Consultation Response from KC Highways Development Management		
2026/91494 Land off Penistone Road, Birdsedge, Huddersfield, HD8 8XP		
Outline application for erection of residential development, including associated infrastructure works. All matters reserved except means of access into (but not within) the site from Penistone Road		
Date Responded: 10/08/26	Responding Officer: M Zenner	Responding Ref: K12-44/7

RECOMMENDATION: There are highway safety concerns in regards to the proposed access arrangements and insufficient information to ascertain the highways implications of the proposals.

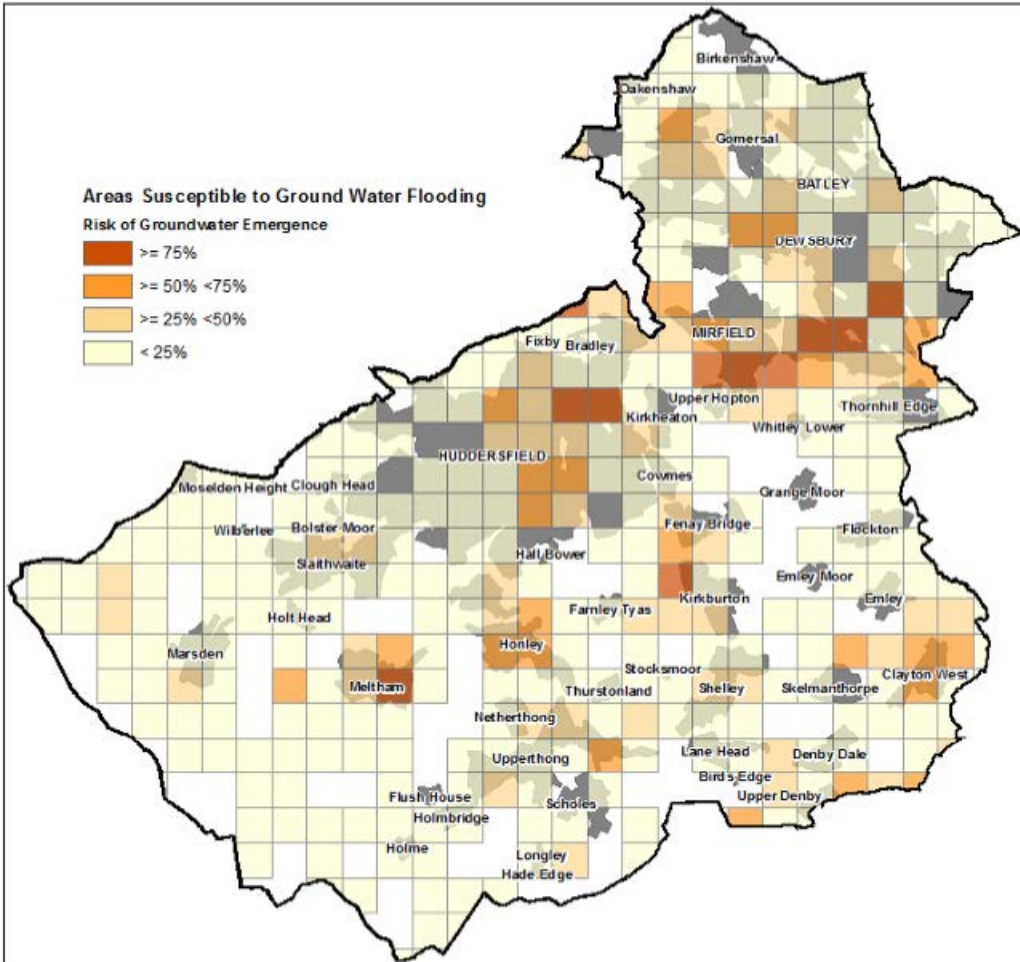
HDM notes the existing stone wall inset within the site frontage within the supplied topographical survey data and requests further clarification as to the future proposals for this retaining feature to ensure that the proposals do not compromise the stability of the highway.
